From: Anita Gardner <Anita.Gardner@arun.gov.uk>
Sent: 27 October 2020 16:00
To: Planning.Responses <Planning.Responses@arun.gov.uk>
Subject: FW: LU/247/20/PL

LU/247/20/PL

Thank you for your email of 25/9/20 letting me know that [revised plans/elevations} have been submitted in the connection with the above planning application.

DRAWING NO: 1908_P_200 REVISION 01

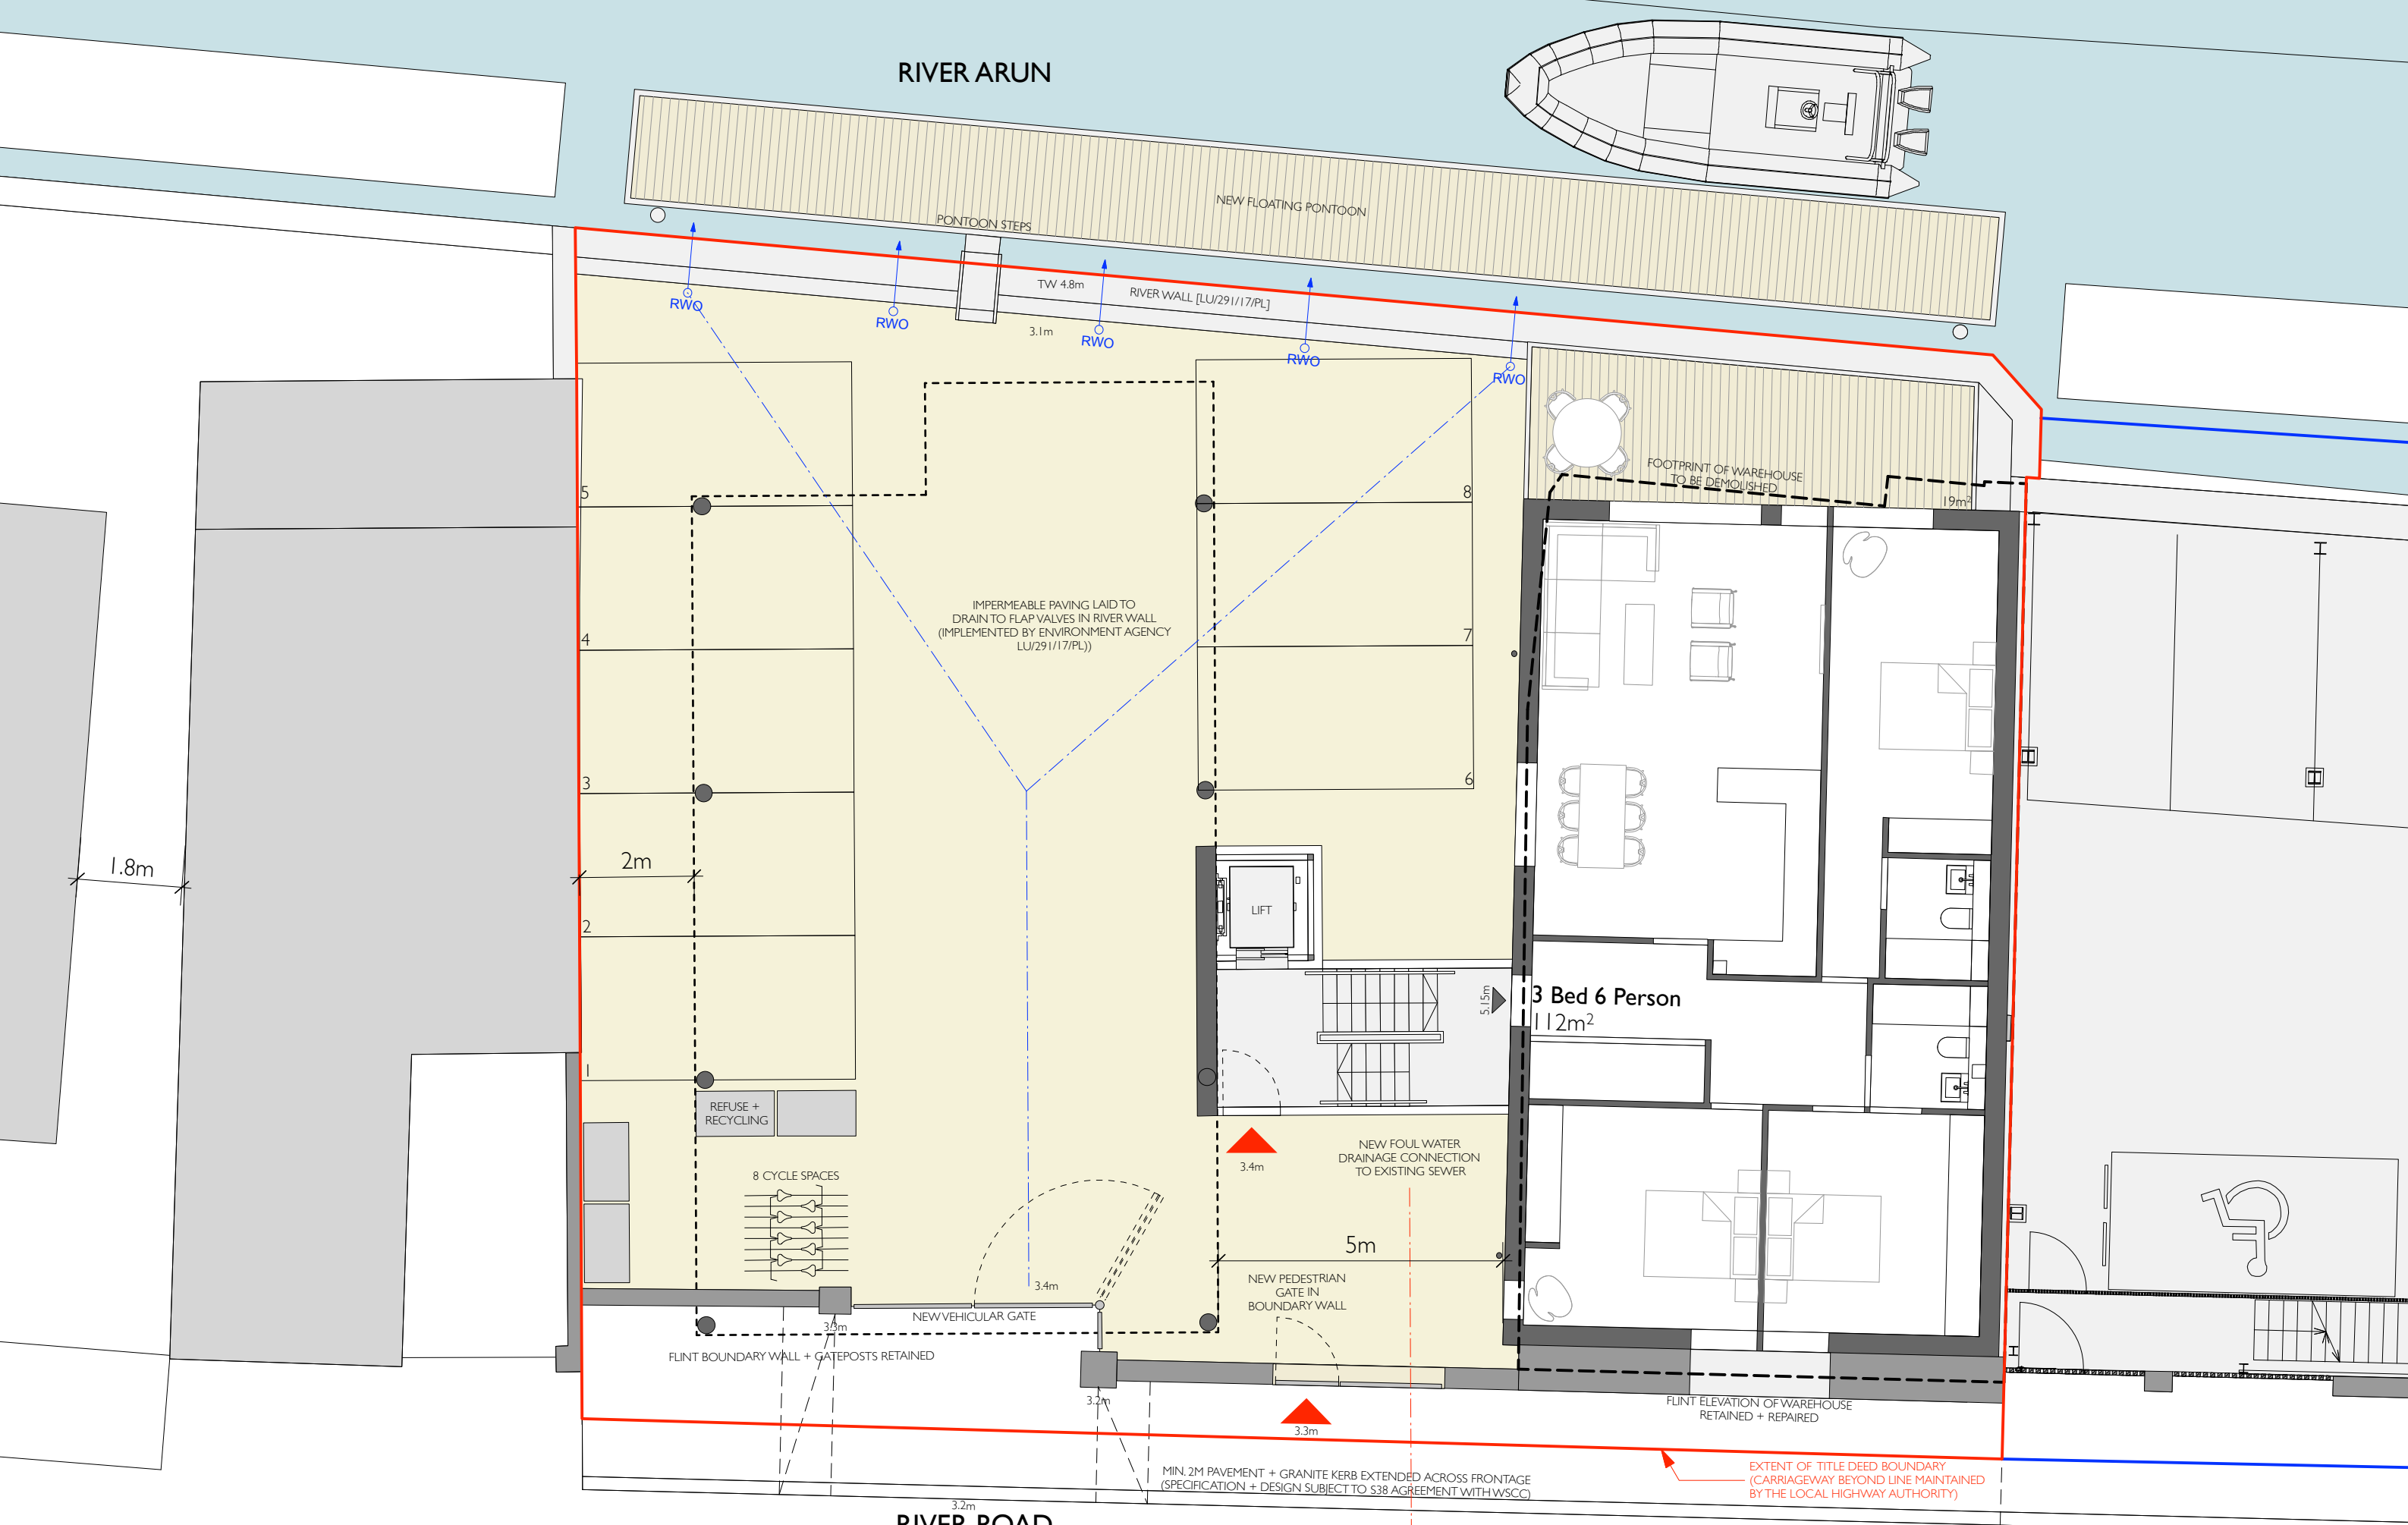
I have carefully studied the revised plans submitted to see if any attempt has been made to mitigate against the loss of light and view I shall suffer as a result of this proposed new building. I fail to see any difference in the revised plans (Rev 01) when compared to the originals other than a slightly shorter pontoon at its southernmost end.

DRAWING NO: 1908_P_201 **REVISION 01**
TITLE: PROPOSED FIRST FLOOR PLAN

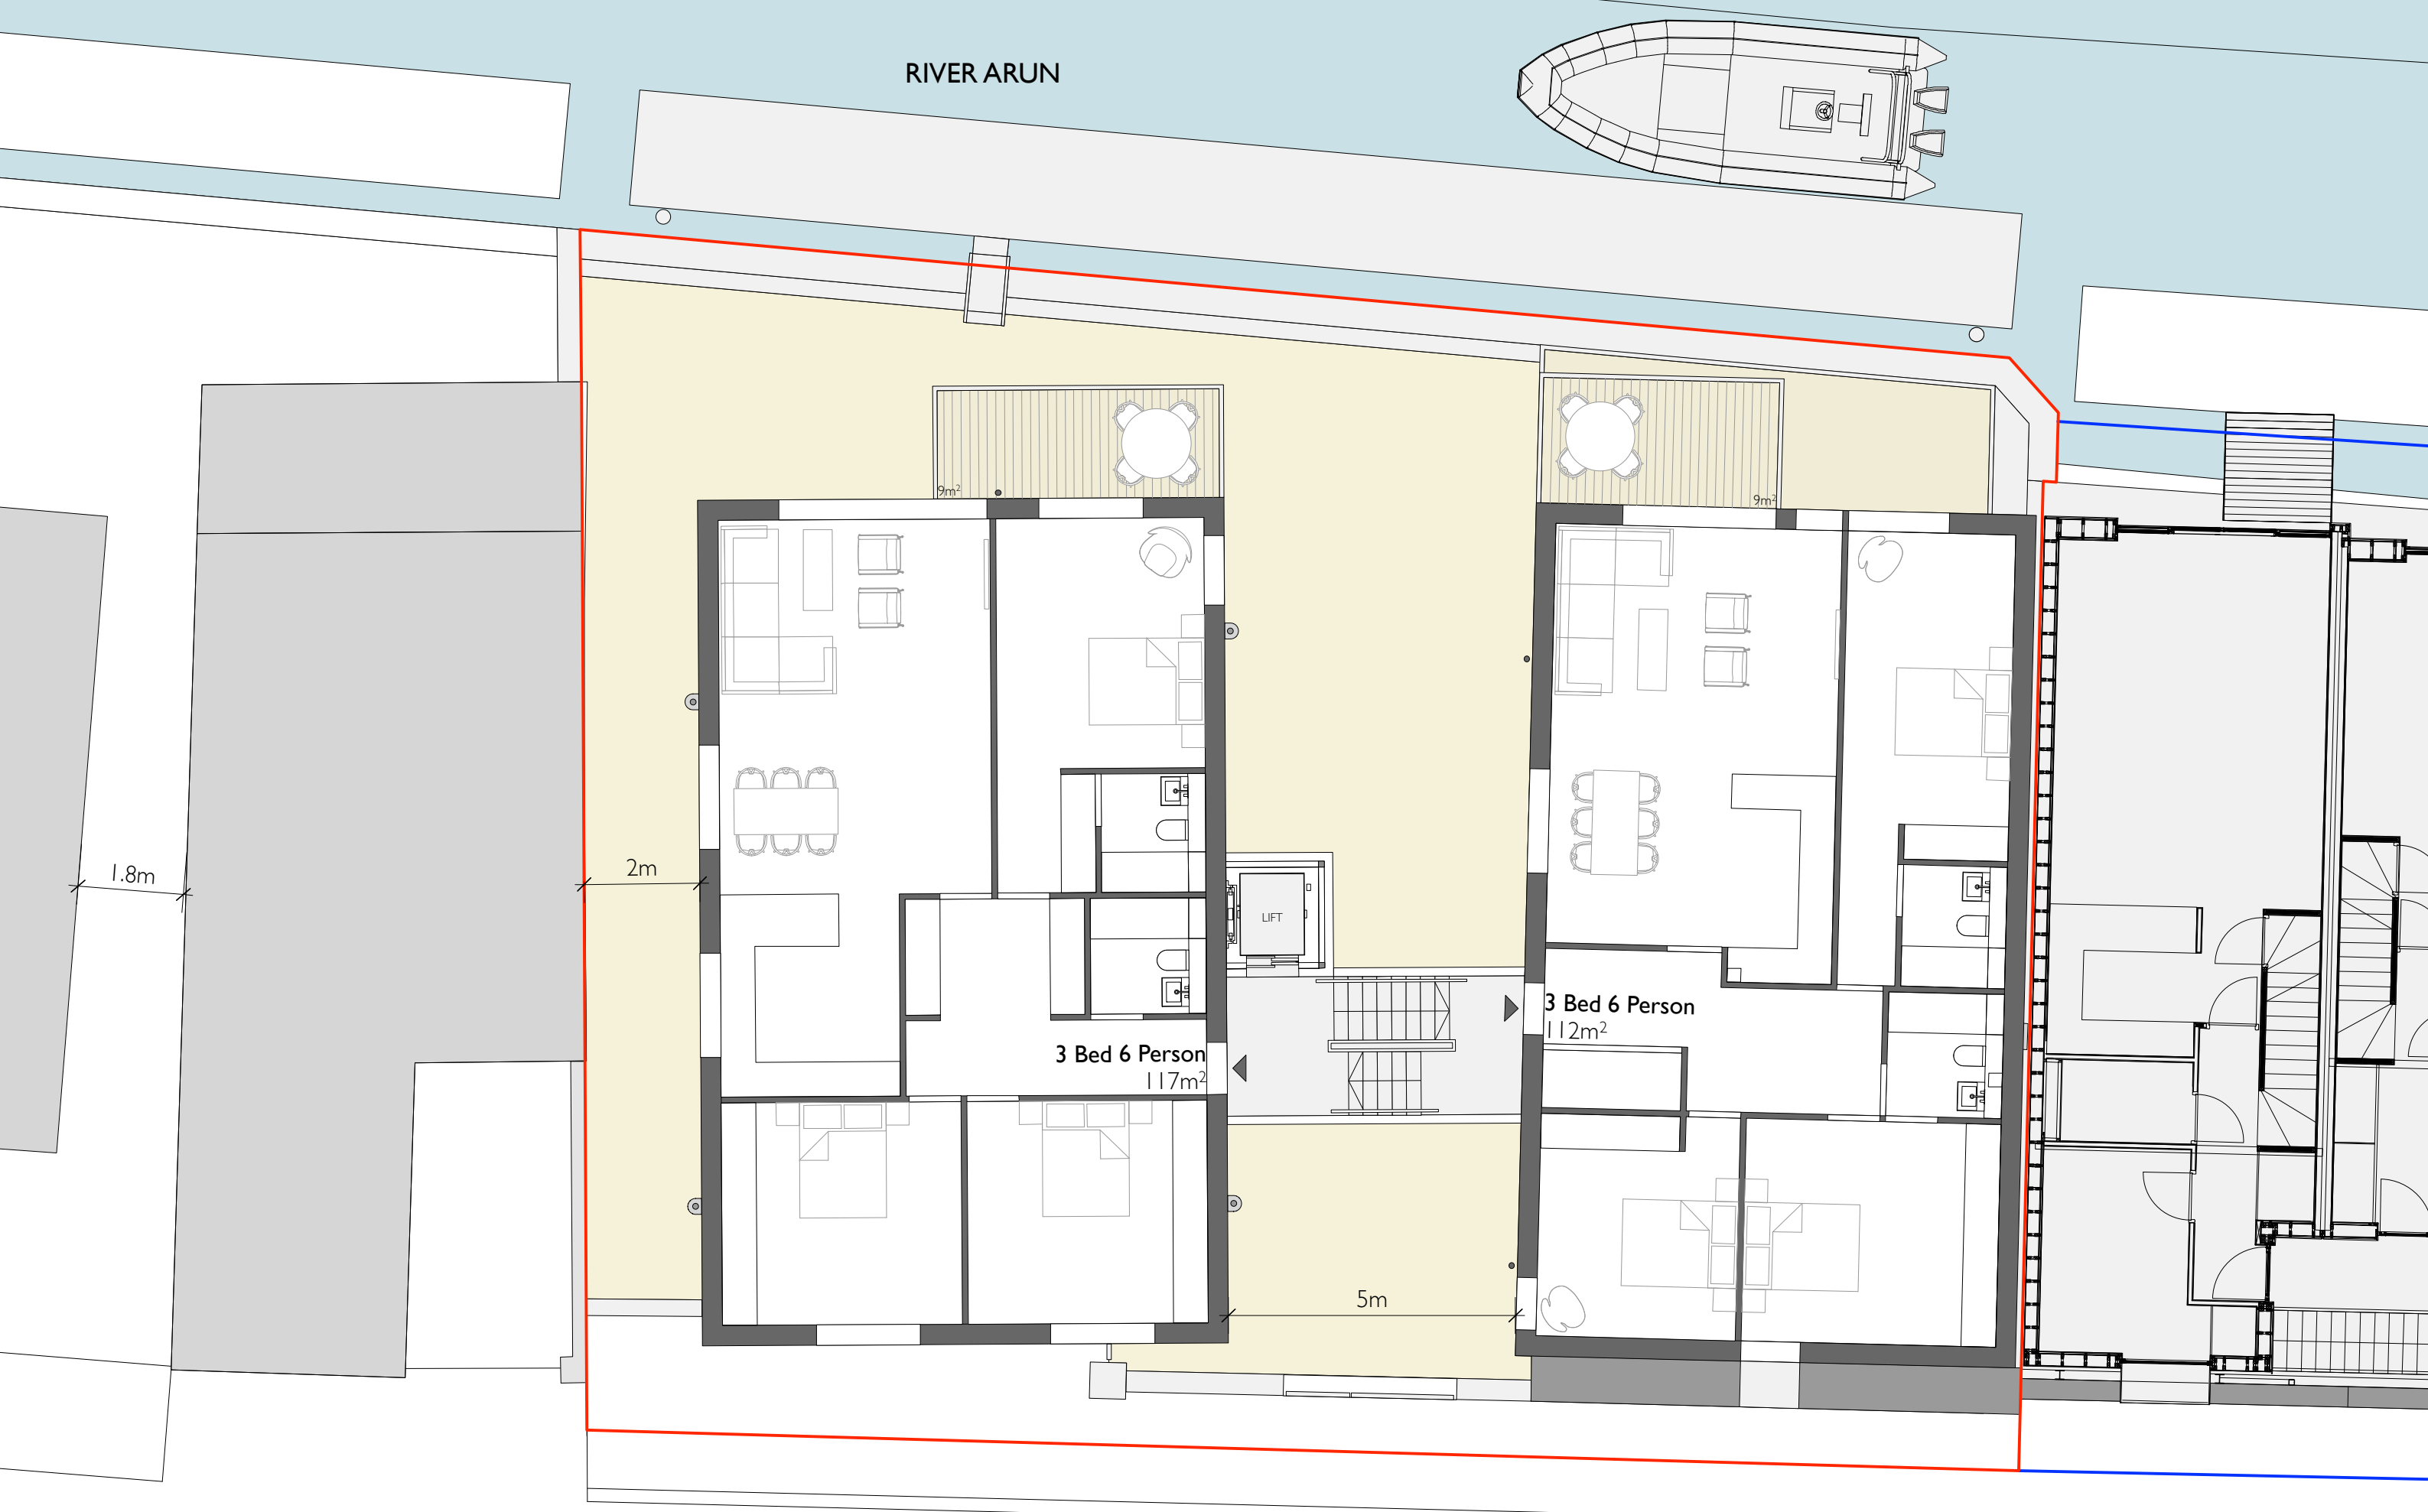
The floor/storey numberings of the original and revised plans submitted are misleading. The floor levels do not align. For example, from the elevation drawings (P1908_P_300) it would appear that what is labelled as the ground floor of the northern block more closely aligns with my first floor, yet the floor plans compare it to the car parking level below.

Similarly for the first floor of the northern block which aligns more closely with my second floor, yet it is the first floor of my building that is shown on the plans.

This is an important detail because it means that the first floor of the northernmost block comes forward of the line of the building for at least three quarters of my second floor level. This wall would block all sunlight until the afternoon, cause shadowing and the loss of a magnificent view downriver which was sold to me by the same person now making this present planning application.

If it is not considered possible to reduce the projection of the building on the first floor at riverside level along its entire length, then perhaps it could be reduced partly for at least several metres away from the existing building. This would also mean that the terrace above would not be so close to my third floor balcony.

DRAWING NO: 1908_P_305 **REVISION 01**

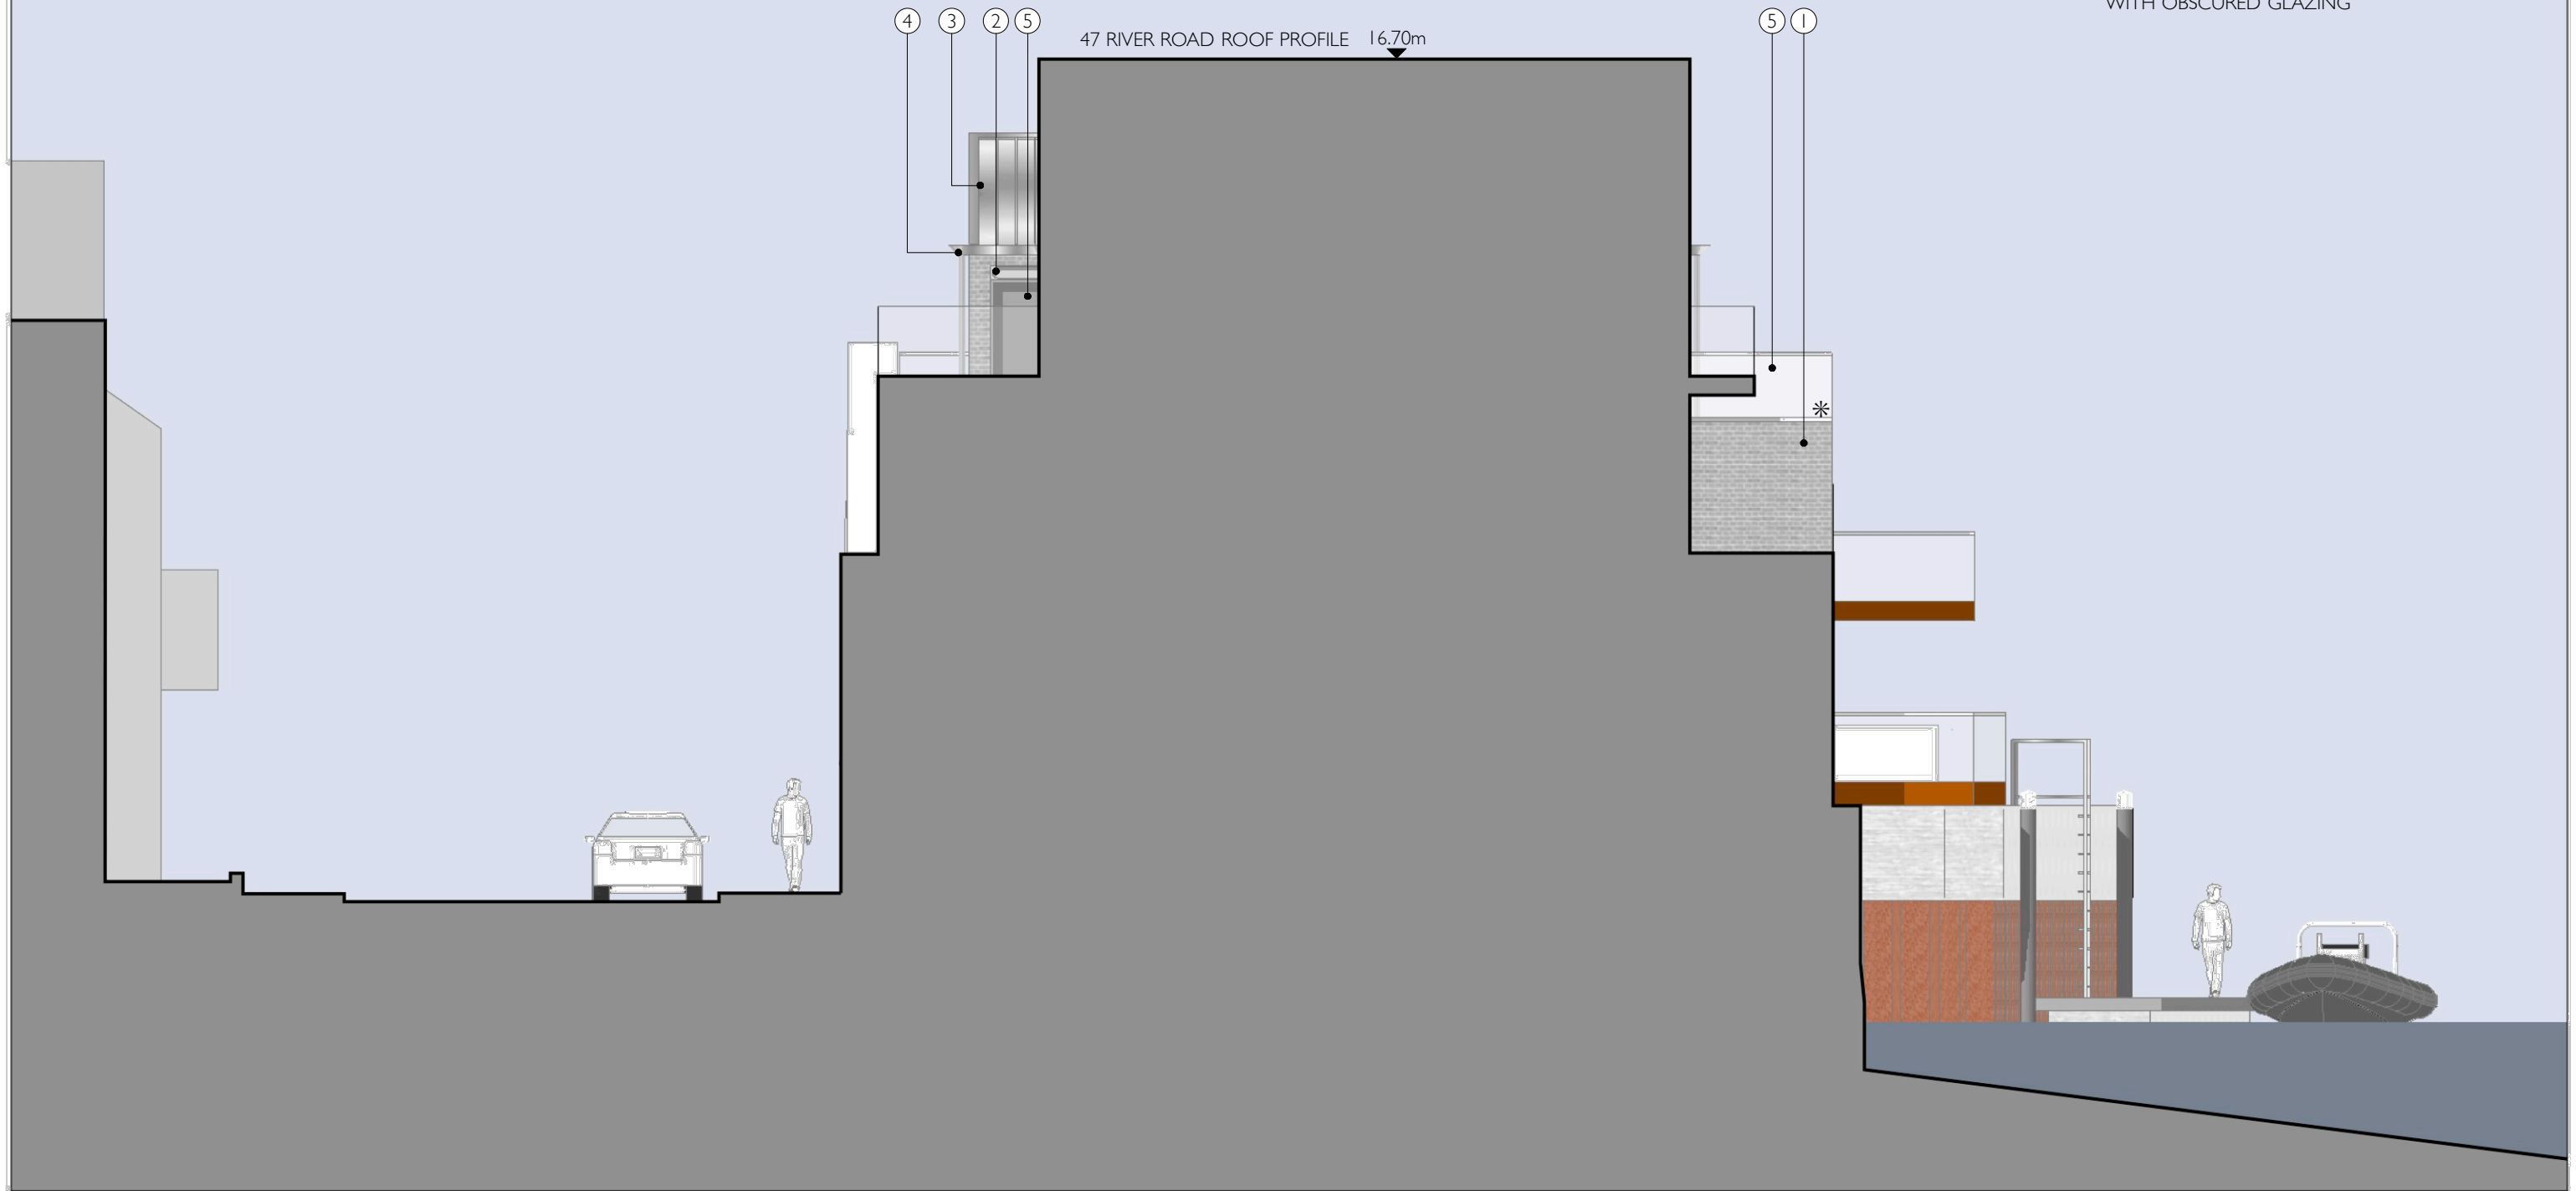
The north-east elevation plan number 1908_P_305 confirms my worst fears that indeed the building will come forward of the line of my house and that I will be left staring at a grey brick wall immediately adjacent to my existing terrace. There will also be unacceptable overlooking issues from the proposed balconies.

I would suggest that no section of the proposed northernmost new building should be permitted to come forward of any of the existing elevations of Riverside Wharf next door to which this new building is being adjoined.
